Subject: RE: 23452 Stakers Farm, Yapton - Y/52/22/DOC Designers Response

Further to the LLFA Response dated 9 December 2022 for information on the Discharge of Condition application Y/52/22/DOC, please see attached the designer's response with supporting documents.

Further to LLFA Response dated 20 September 2022 for information on the Discharge of Condition application Y/52/22/DOC, we have attached updated drainage drawing 201A_Proposed Drainage Plan together with revised calculations and construction details based on the comments received.
We reply to the following responses below in green as follows:

TITLE
Proposed Drainage and Levels Layout plan

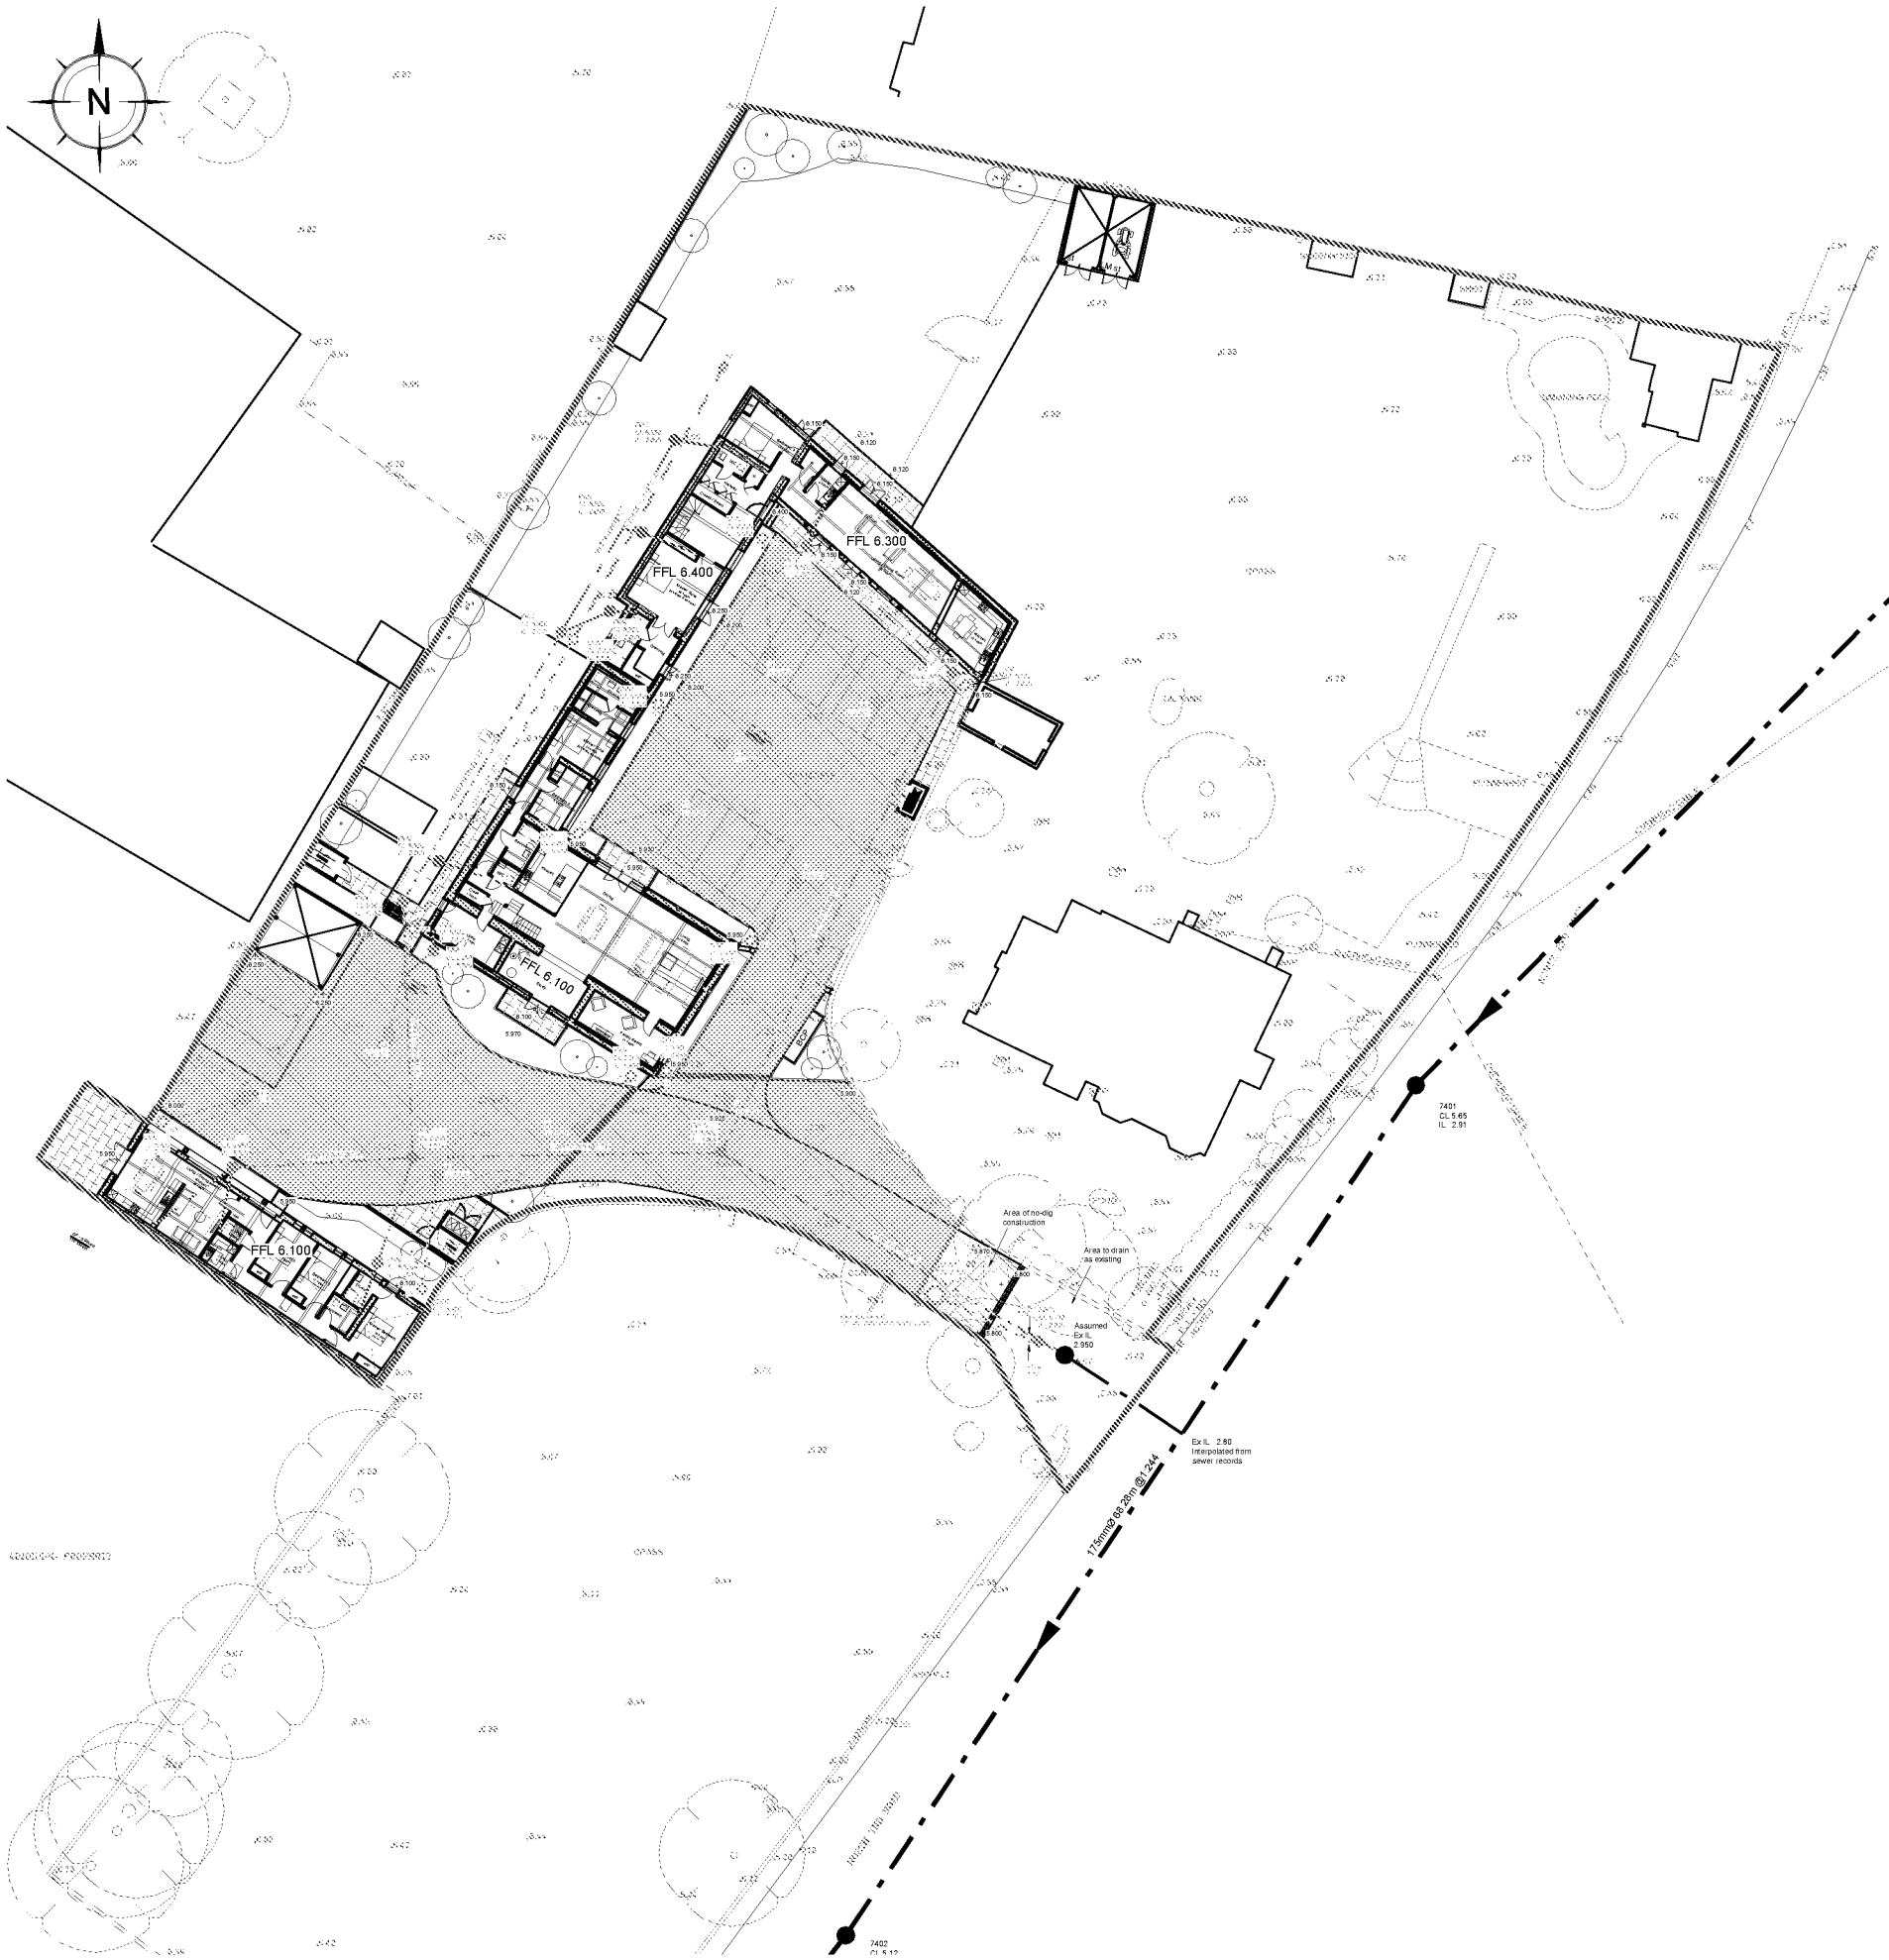
6. The drainage calculations should typically include an allowance for urban creep. In this case, we are satisfied that there are limited opportunities for including additional hardstanding, however, the applicant should provide a justification for its exclusion within the report or calculations. 10% Urban creep has been included within the calculations. The impermeable area of the proposed roofs is 715 m^2 and with 10% urban creep of the roofs of 72 m^2 , the total area used for the roof is 787 m^2 and the area for the carpark used is 1000 m^2 . The total area used for the calculations including the urban creep is 1787 m^2 or 0.179 ha as shown on drawing 103A_Impermeable Areas Plan and the updated calculations.

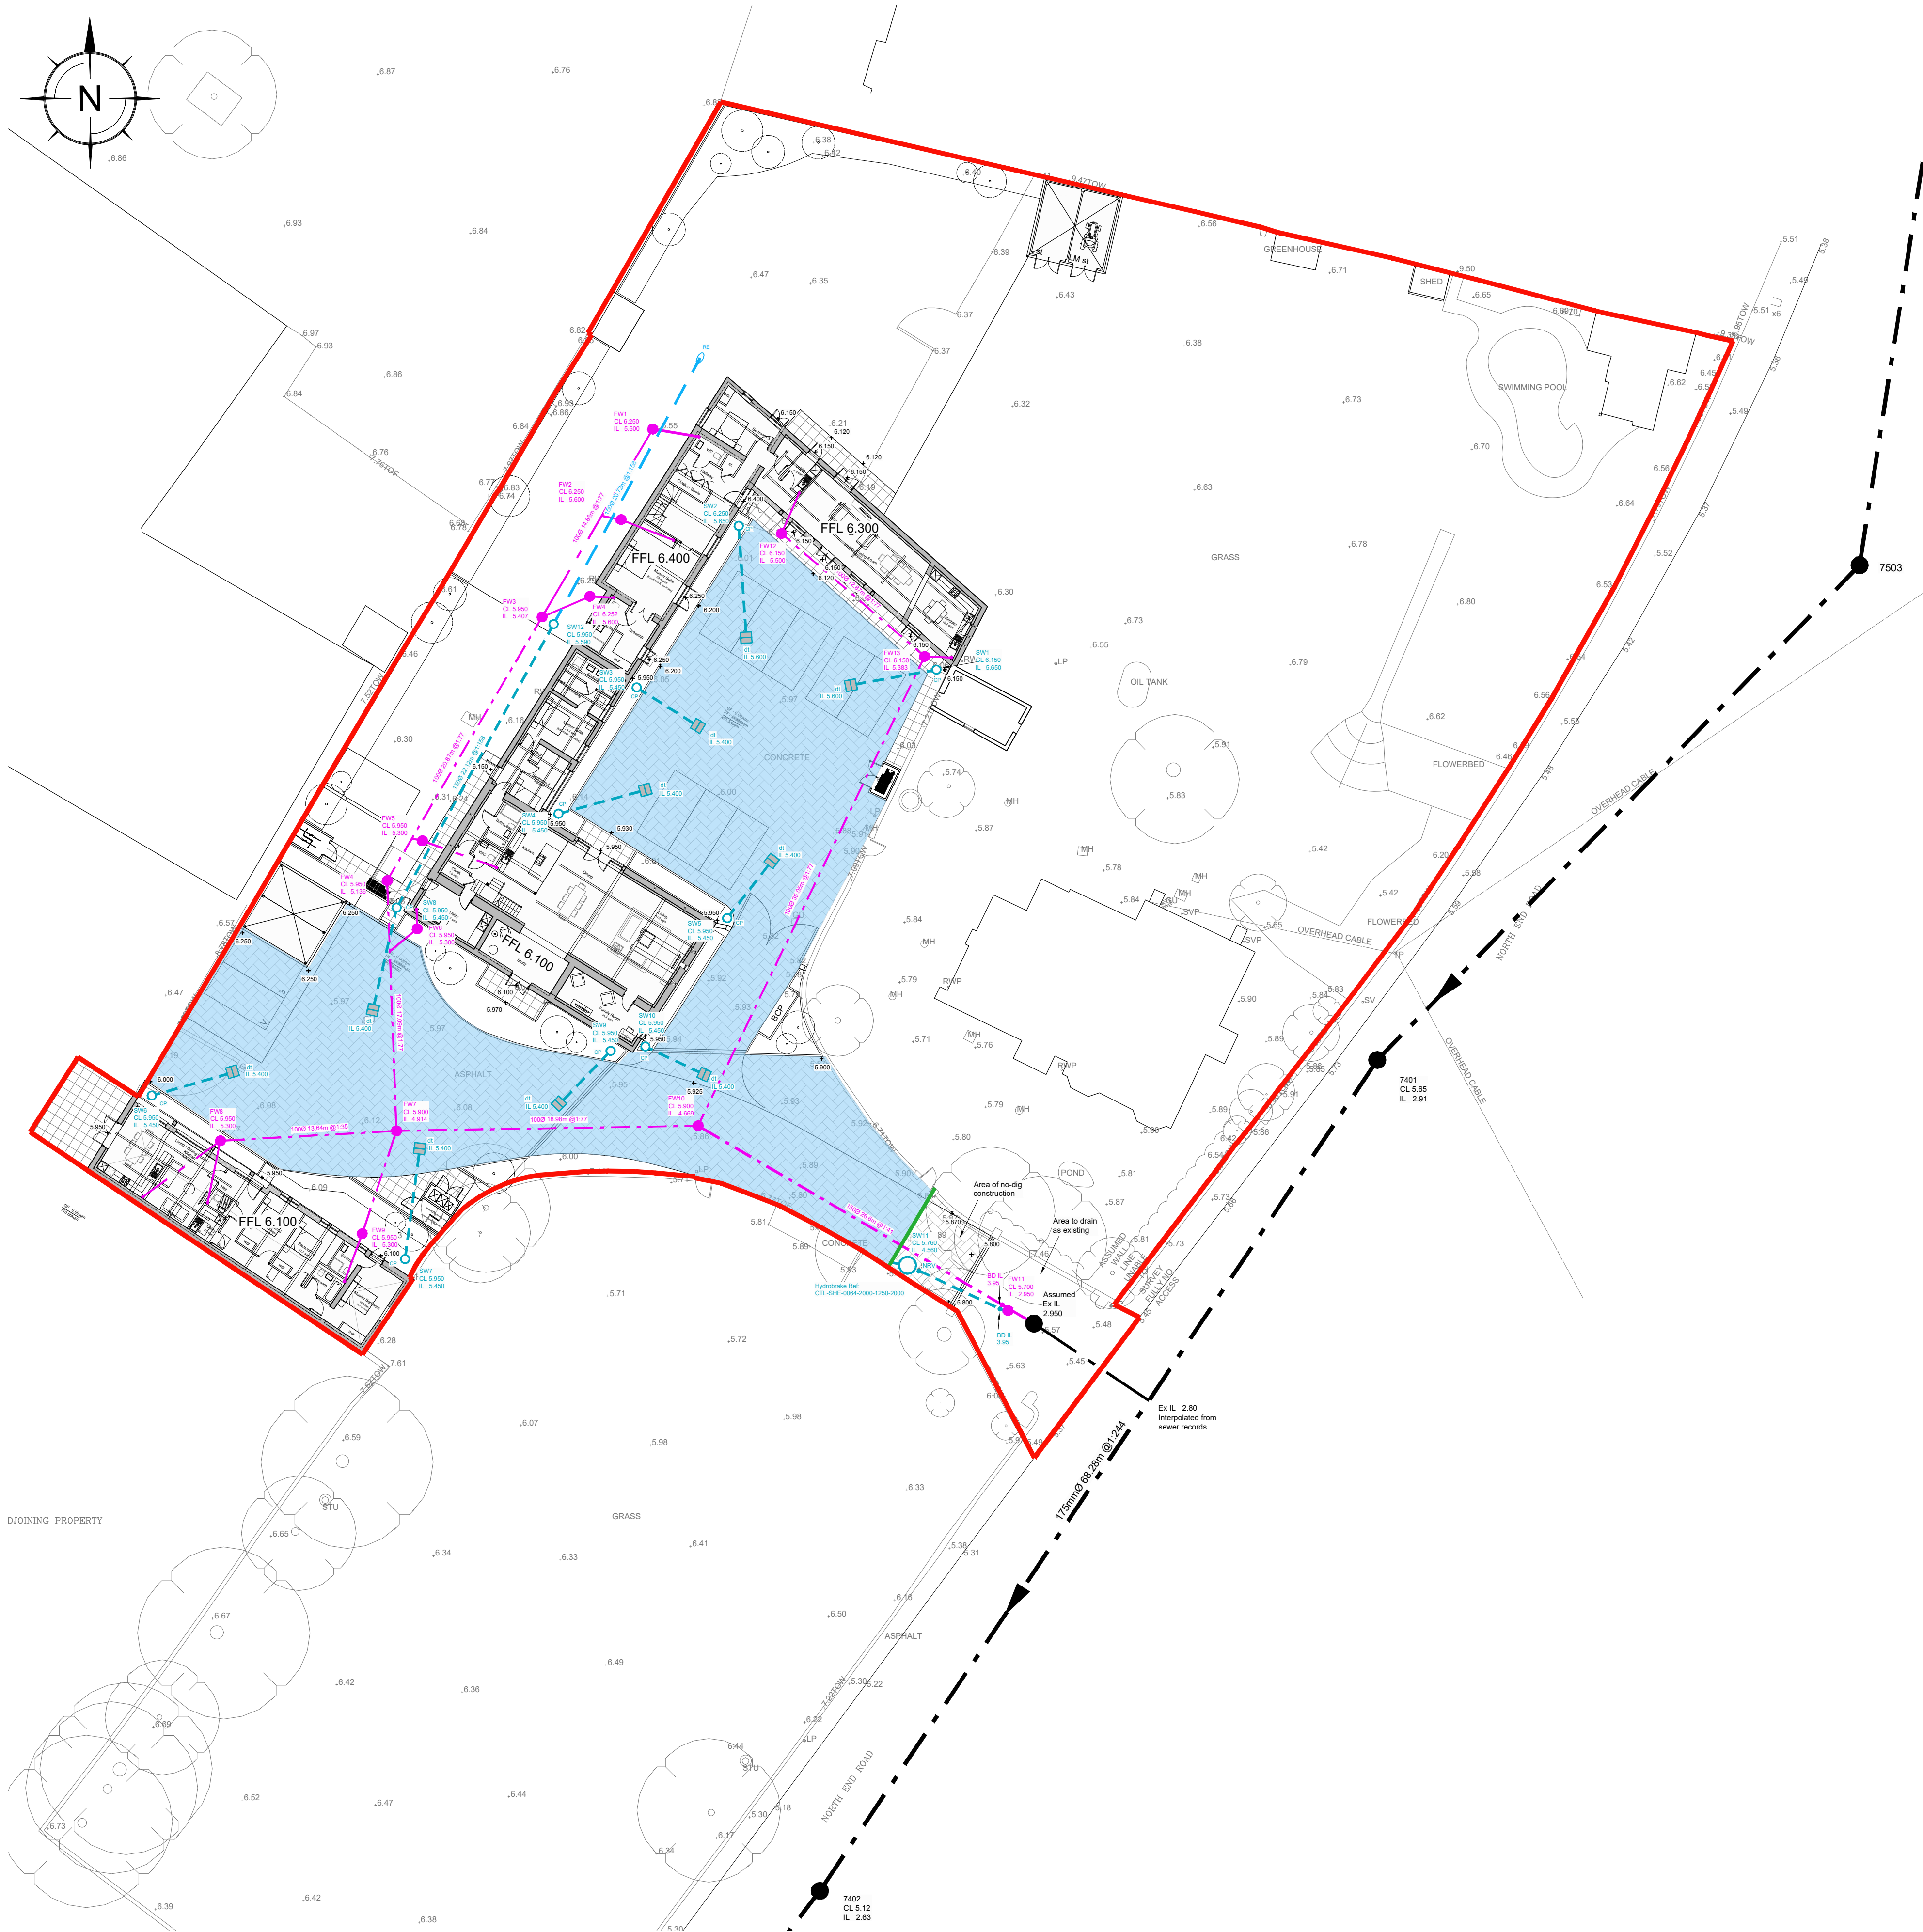
- Service corridors for other services provided to the buildings should be shown, or a statement provided detailing how these will be successfully implemented within the scheme. Service trench corridors have been included within the drainage strategy noted on drawing 201A, copy attached.

4. The applicant should explore the potential to connect into the existing highway drainage network, prior to proceeding with the proposed connection to the public foul sewer system, which should be taken as a last resort. We require confirmation of approval for any highway or sewer connection.

- We appreciate a reduction in flows has been achieved, however, we need to see agreement with Southern Water for any connection to the public sewer system. In this case, we also note our mapping shows a surface water highway drain on the opposite side of the road to the proposed development, which would present a preferred point for discharge in our hierarchy of discharge options. We therefore require:

- The design to be amended so that runoff is discharged into the highway drainage network, alongside an agreement with West Sussex Highways for this connection. Approval for a connection to West Sussex existing highway drainage has been requested, however, as there are no surface water sewers within the area, it is likely that the highway drain either discharges to the public foul sewer or to a soakaway. If it is to a soakaway, there will be no capacity to accommodate additional surface water drainage from the site. If it is to a foul sewer, we would propose a direct connection as indicated on the submitted drawings

- Justification for why a highway connection is not possible, (e.g. confirmation from Highways that they will not permit a connection in this area) and an agreement with the sewerage undertaker for the proposed connection.
- This is particularly important as the development site is located within the Lidsey treatment catchment. Highway approval has been requested, although we note there is no right of connection to a highway drain. Southern Water has a statutory duty to accept surface water into the public foul sewer provided that the

options for discharge from the drainage hierarchy have been followed. There is therefore a connection available for the surface water discharge from the site and the connection should be discharged.
